Subject: RE: Planning Application FG/220/18/PL : Land adjacent to Elm Lodge, Tamarisk Way, Ferring, West Sussex BN12 5ER

In order for me to remove my objection I am going to need some further information to be supplied:

EXISTING POND ACCESS
PLAN

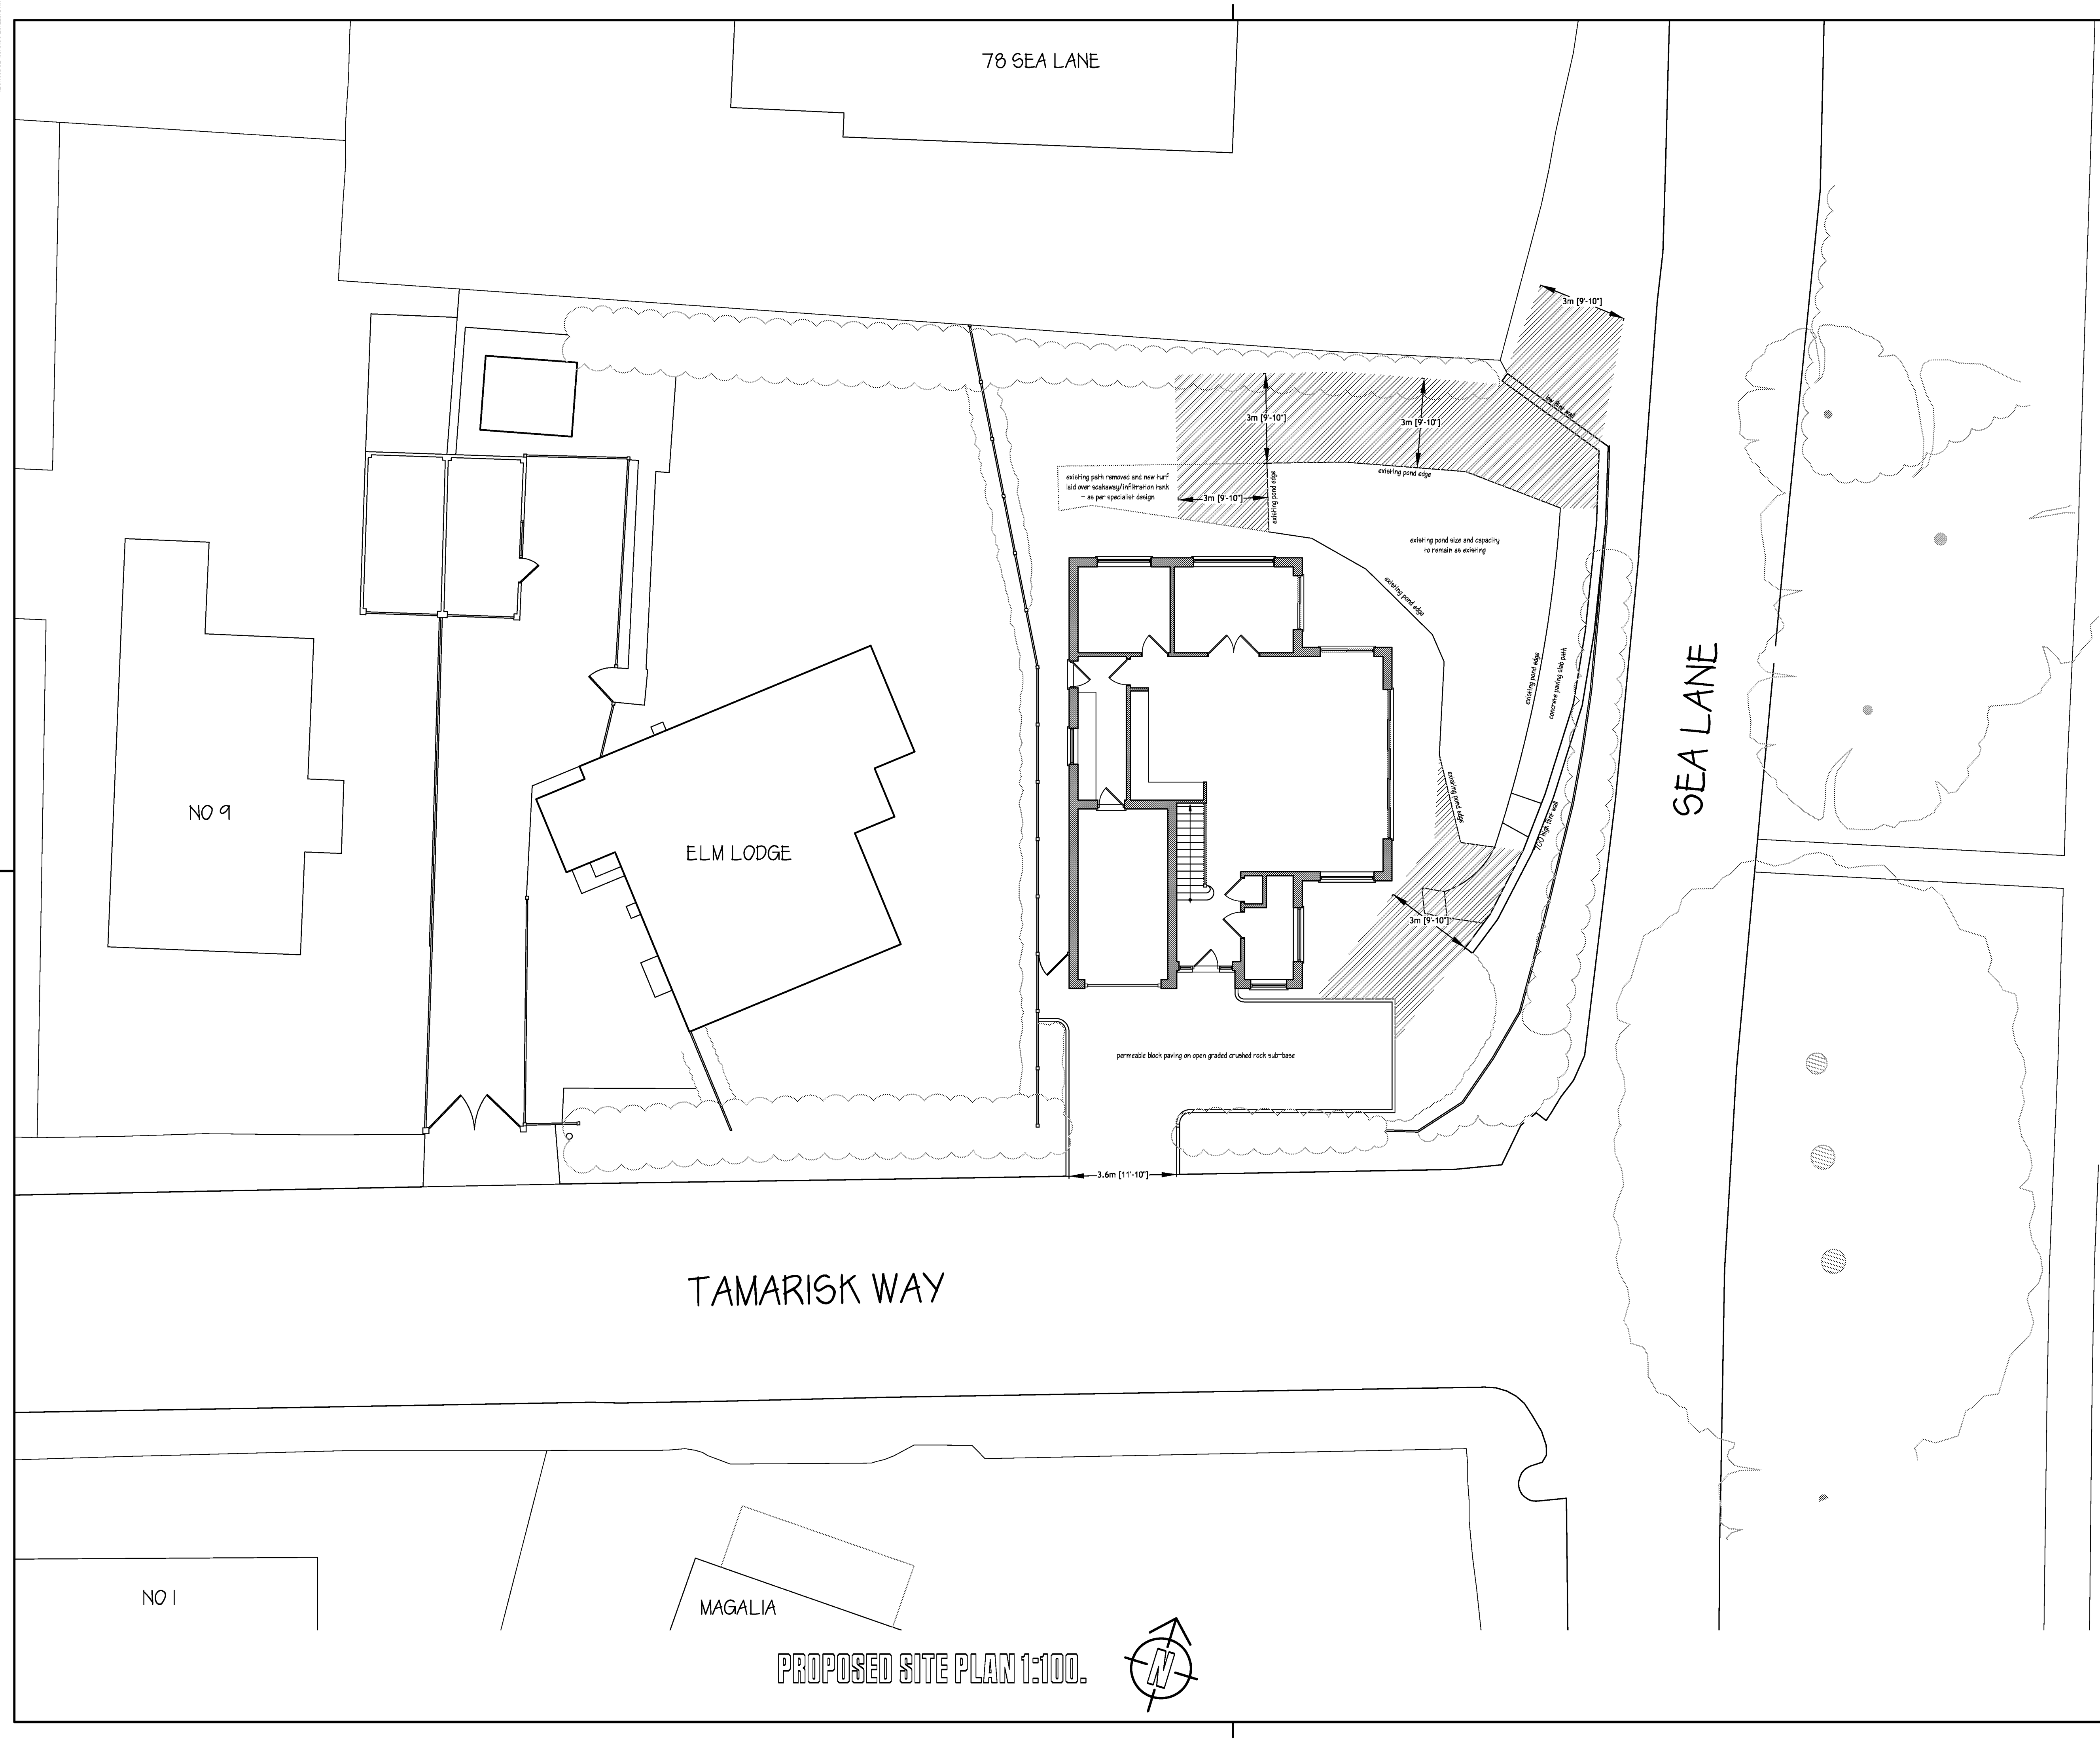
1. Please identify whether a pipe exists at the western extent of the pond. This will impact upon if I believe there is a likelihood you will have sufficient space for surface water drainage. The soakaway that you are currently proposing is located directly on top of the suspected pipe location.

2. I am not keen to see the building go up to within 0.8m of the pond. Access and erosion are both a concern. I would therefore be keen to see the building layout revised to provide more easement.

3. It is my belief that there is no way to get to the northern and western portions of the pond without tracking through the pond itself. This would mean that maintenance would have to be completed in the summer by the landowner when water levels are lower. This would then be within nesting bird season. I would much prefer an access to be provided around the pond. I note that you state the 1m wide path to the east could take plant but this plant would not be big enough.

Further to our meeting at the land adjacent to Elm Lodge, Tamarisk Way, Ferring, West Sussex BN12 5ER on 12th February 2018, please find attached the existing and proposed pond access plans as requested. These show the existing pond to be retained in its entirety, with 3m access provided should Arun District Council ever need to access our property to maintain the pond. We hope these now alleviate your concerns regarding potential future access. We also note that the path to the east of the pond is also over 1m wide, which can currently comfortably accommodate a 1.5 ton digger to carry out any works. Given that there are multiple points of entry along the edge of the pond, any further work can be carried out from within the pond.

PROPOSED POND ACCESS
PLAN

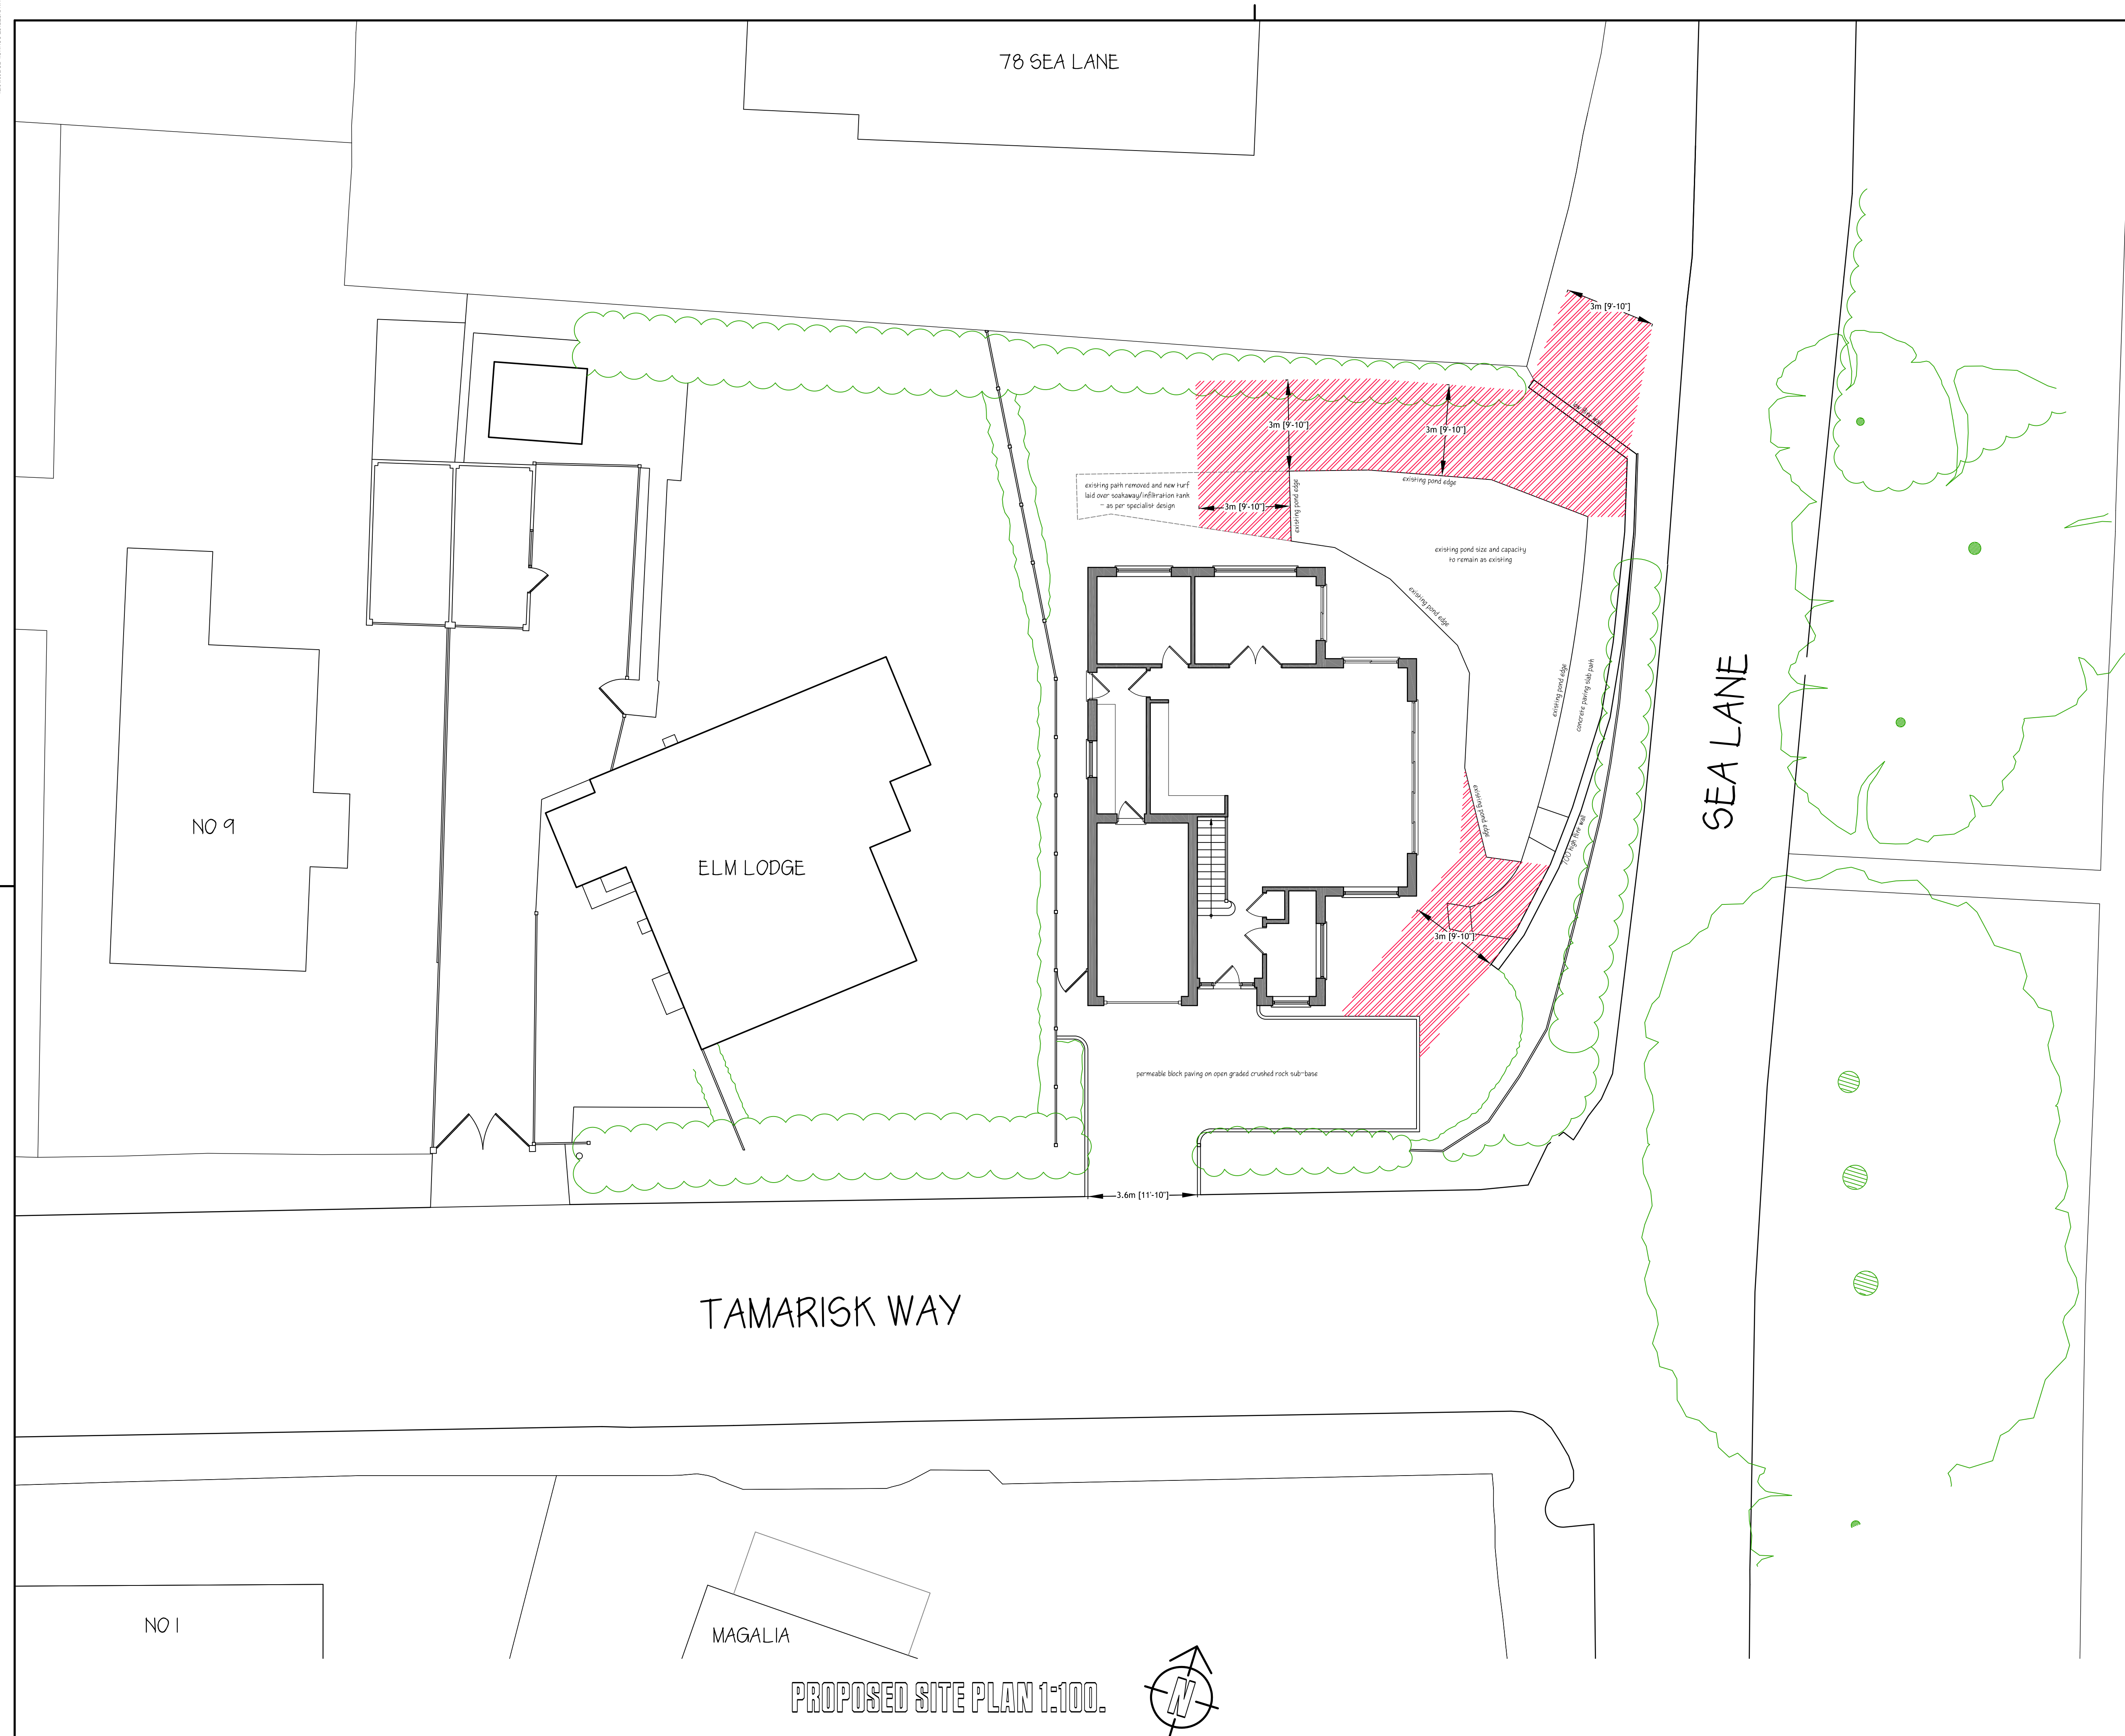
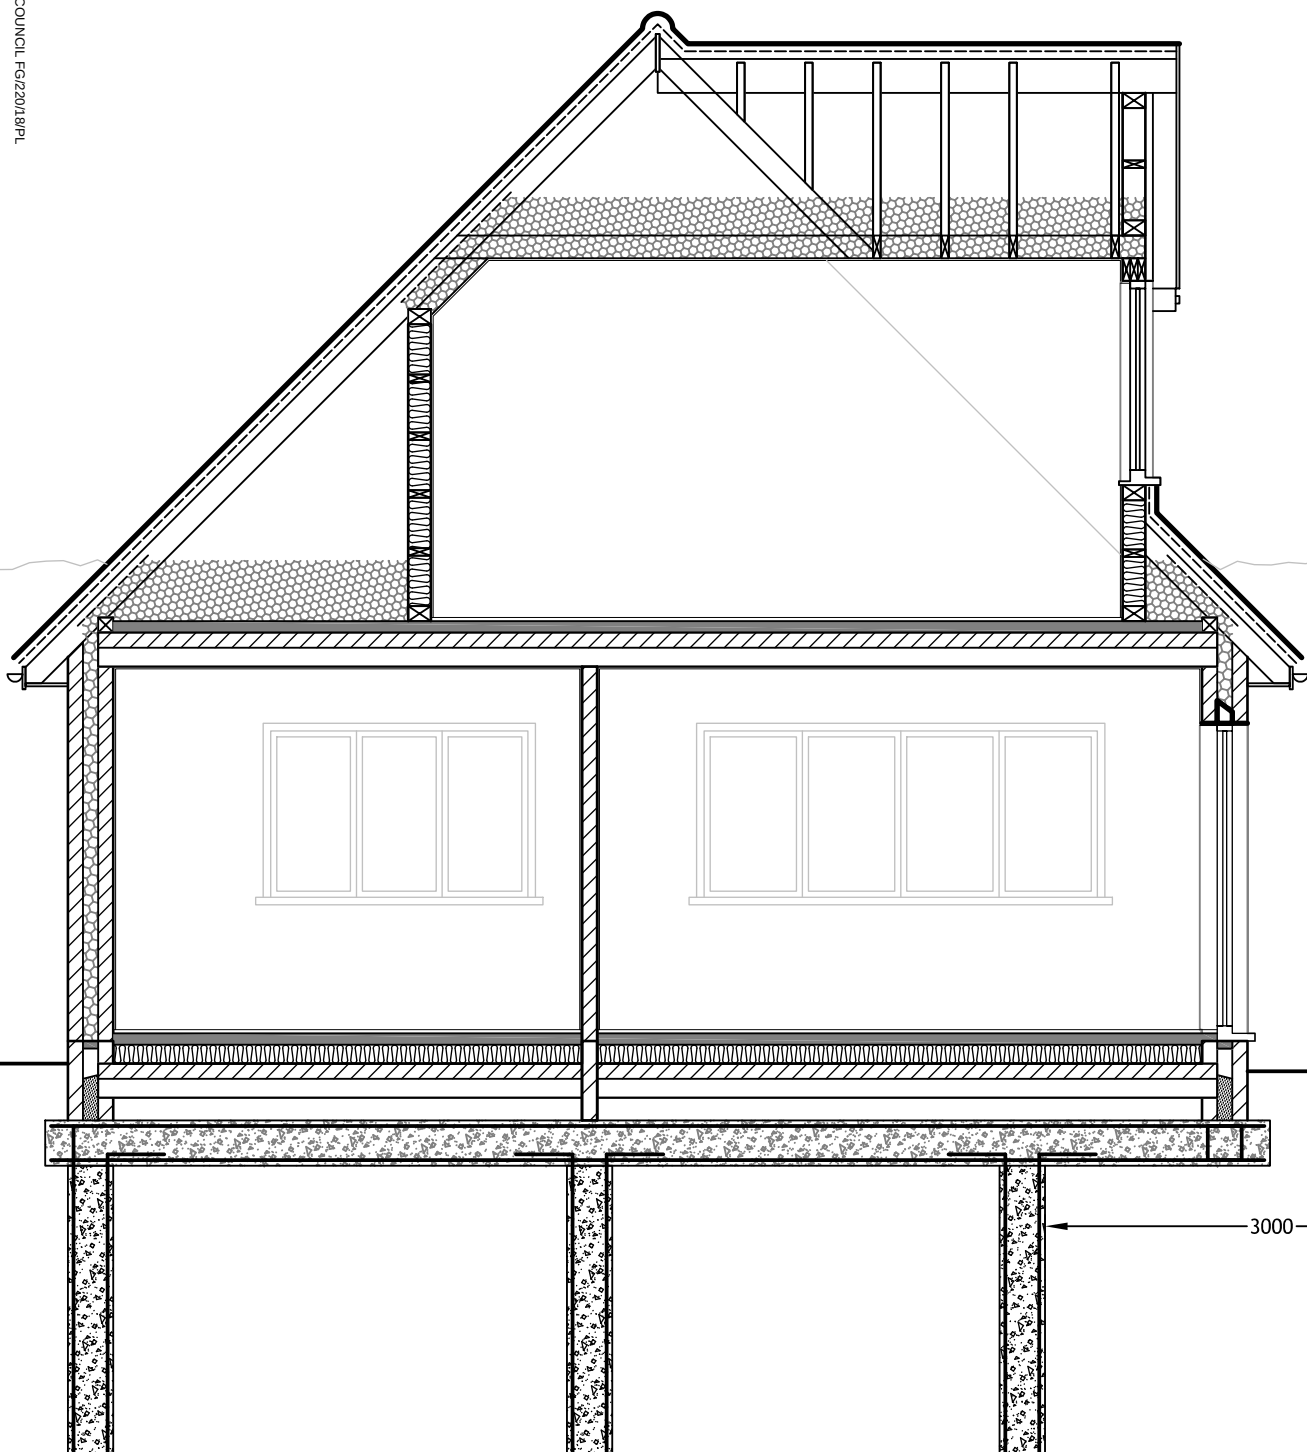
4. It also needs to be demonstrated that the volume of pond to be infilled will be compensated for elsewhere.

We also attach an indicative proposed part foundation section detail to show proposed short bore piles a minimum of 3m from the edge of the existing pond. There will be no encroachment or structural implications for the pond.
